WEST SUSSEX COUNTY COUNCIL CONSULTATION

TO:	Arun District Council - FAO:Anita Gardner
FROM:	WSCC - Highways Authority
DATE:	12 January 2022
LOCATION:	Land rear of Paynters Croft Burndell Road Arundel BN18 0HR
SUBJECT:	F/22/21/PL 23 No dwellings with associated access, infrastructure, landscape and open space (resubmission following F/5/21/PL). This application is a Departure from the Development Plan & is in CIL Zone 3 and is CIL Liable as new dwellings. More information received.
RECOMMENDATION:	No Objection

Drawing Status	FINAL						
Client	Driftstone Homes						
Project	Burndell Road, Yapton						
Drawing Title	Proposed Access Road Overview and Dimensions						
Scale	As Shown	Date	Sept 20	Drawn By	SMO	Checked By	ALB
Drawing No.	2020-6145-002				Rev.	I

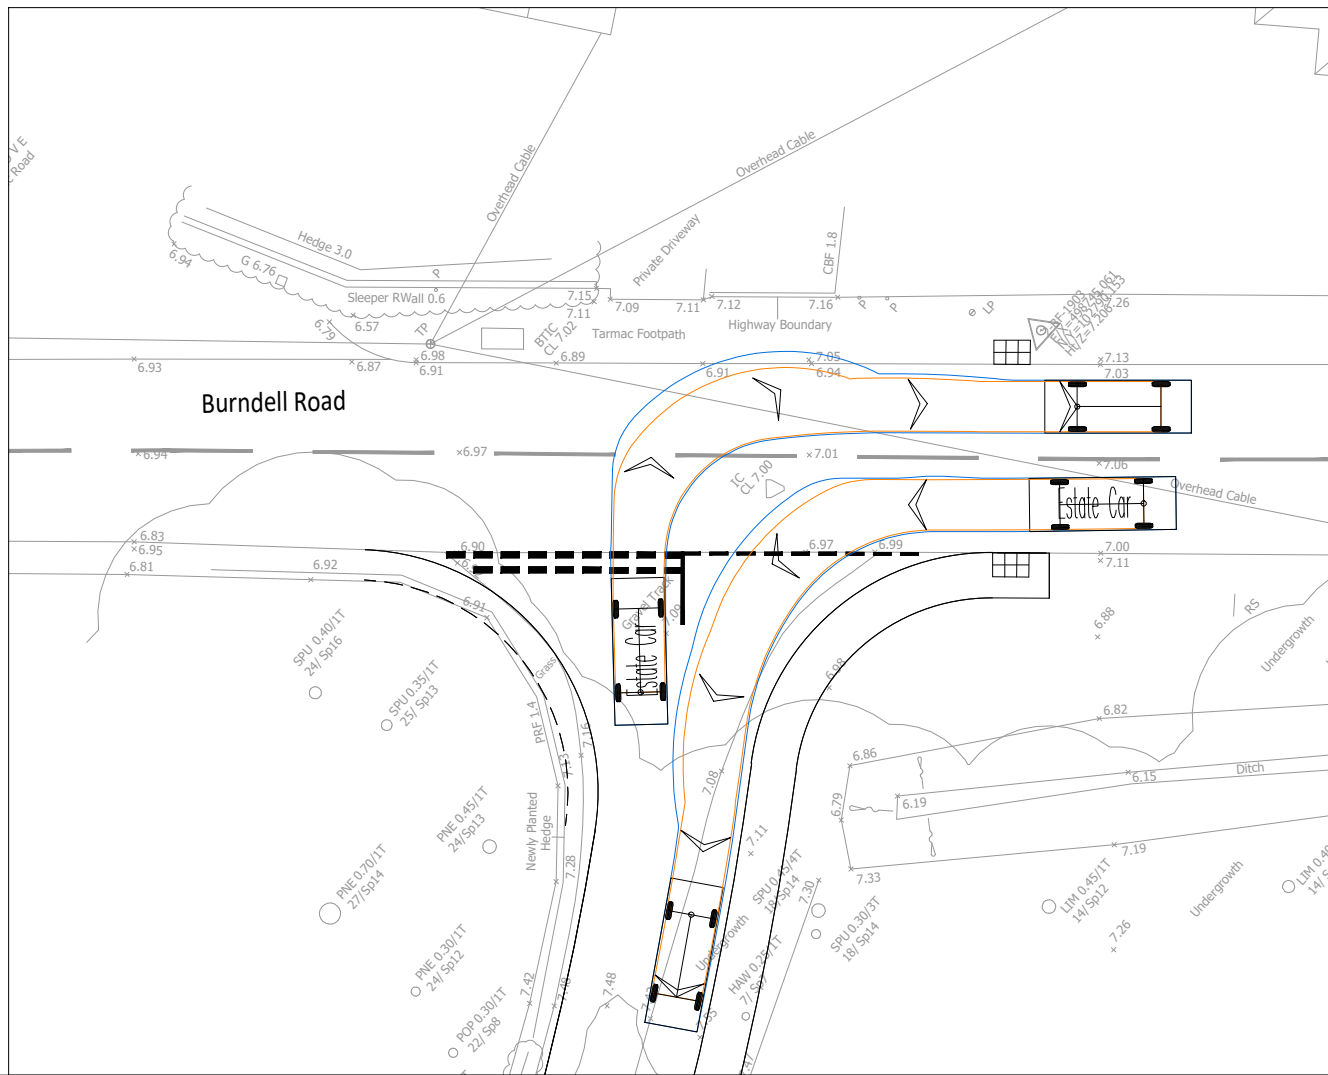
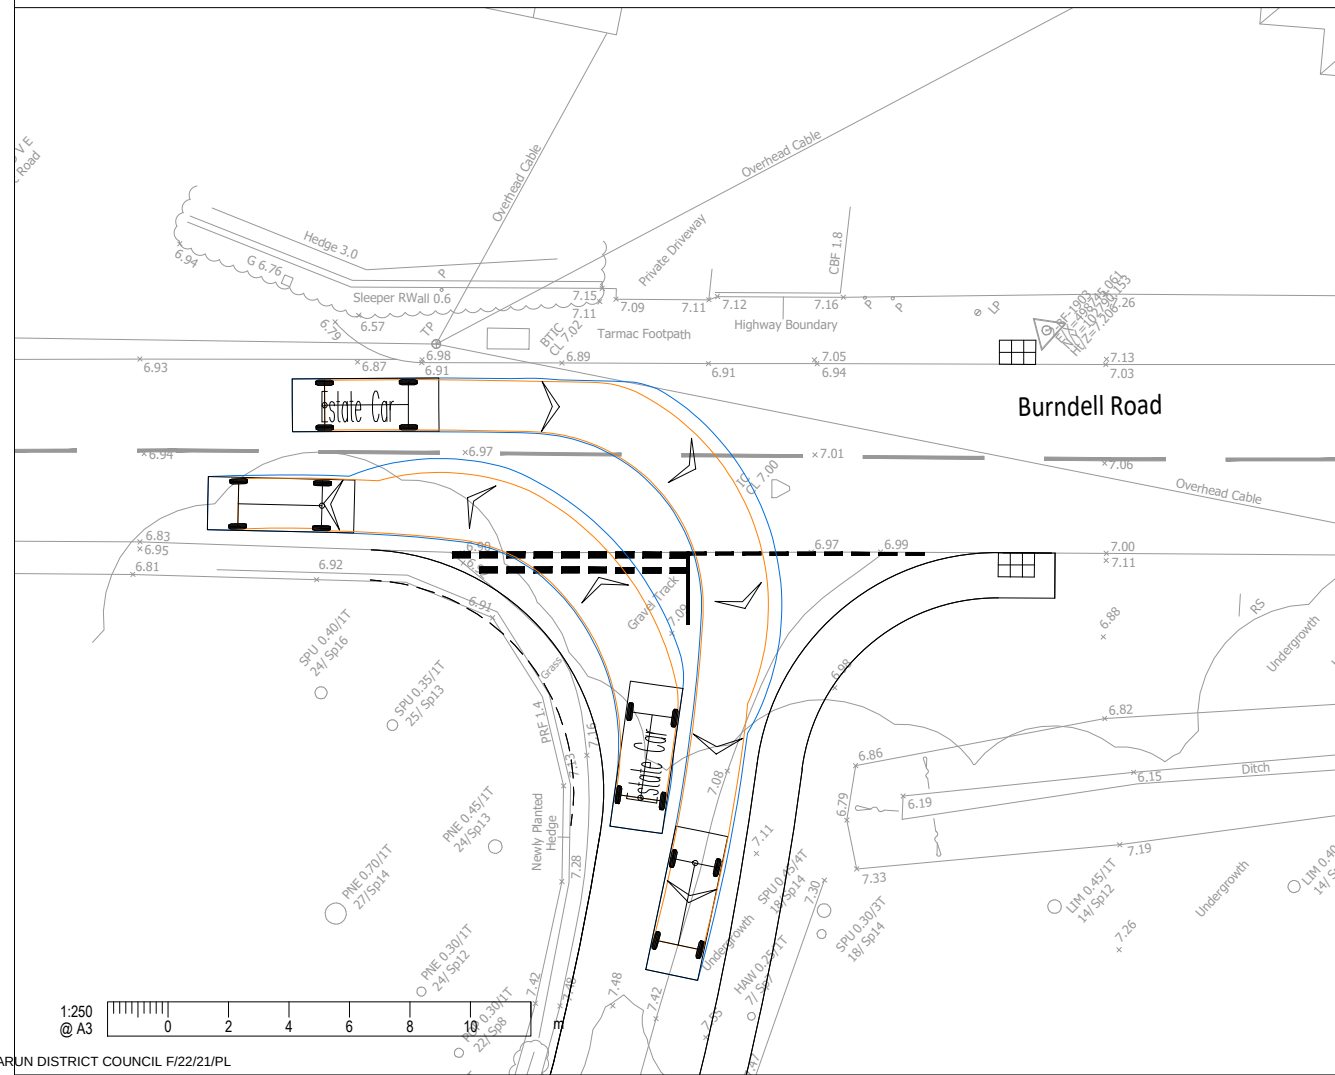
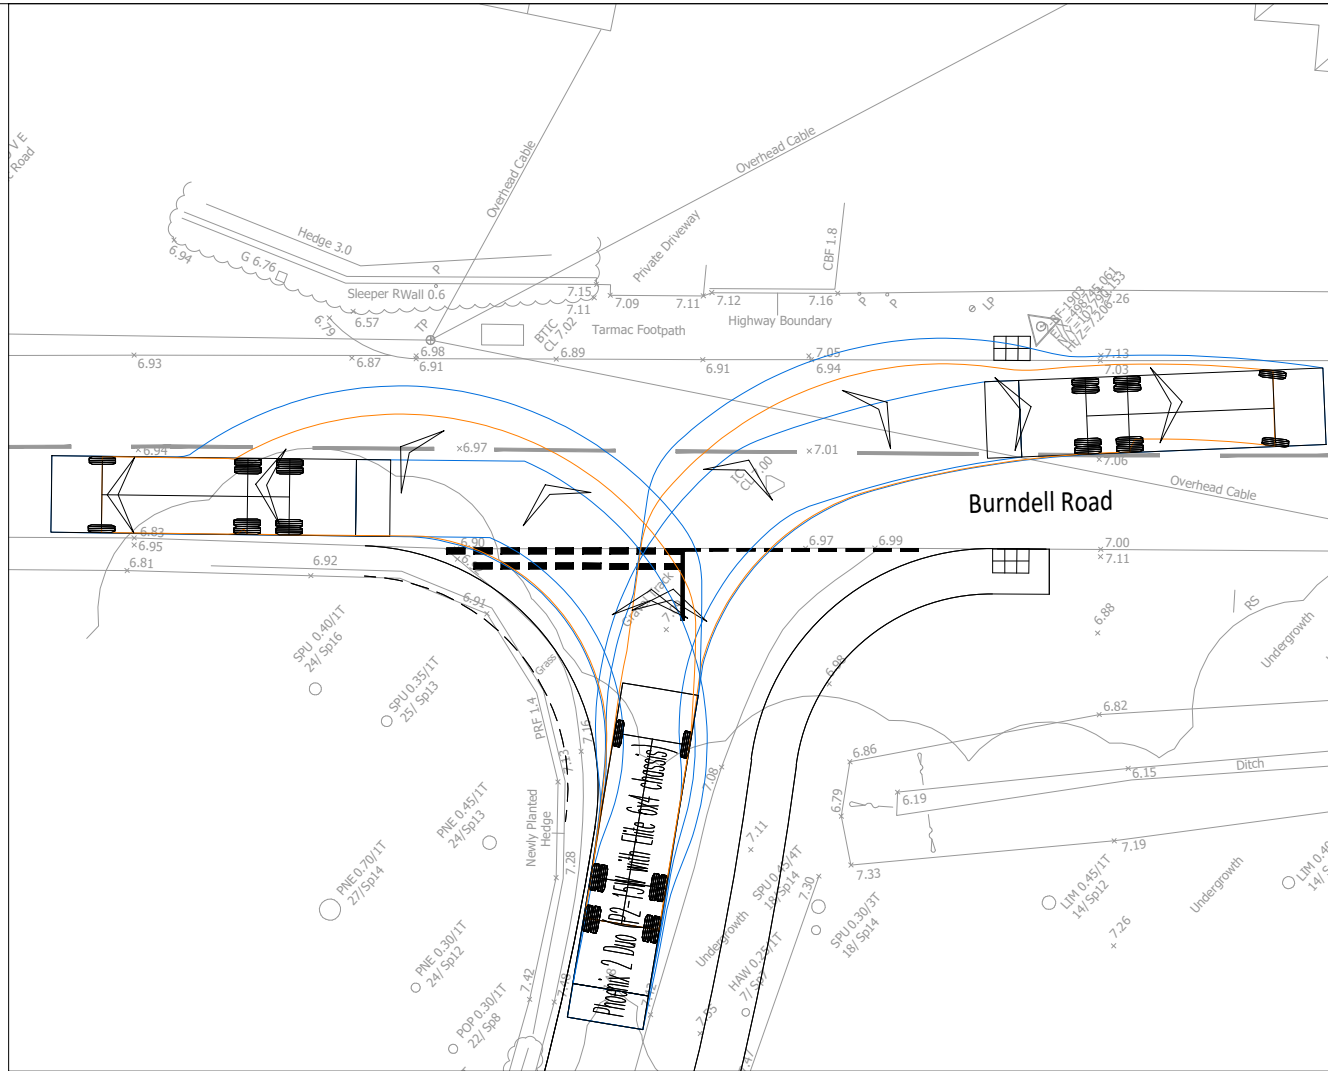
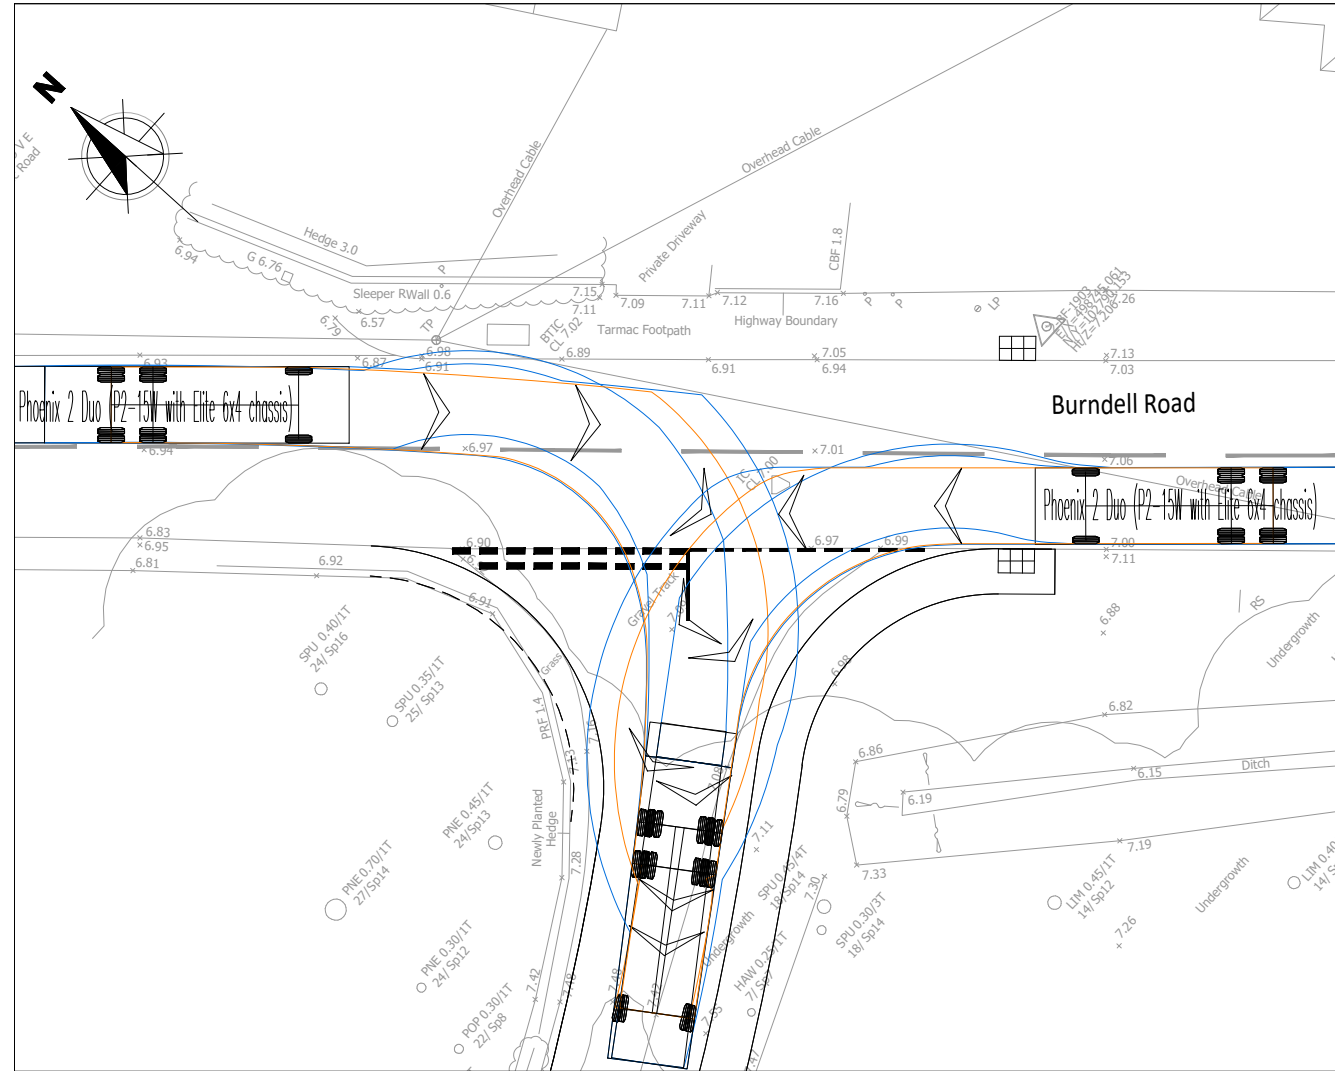
- Show splays of 2.4m by 58m south and 60m north can be accommodated without passing through third party land.
- Clearly show extent of footway from access road past plots 1 and 2.
- Ensure single garages of 3m width.

Drawing no. 2020-6145-002 Rev I (Proposed Access Road Overview and Dimensions) shows the correct access road footway arrangement and the Site Overview plan confirms that the footway will continue past plot 1 and 2 within the site.
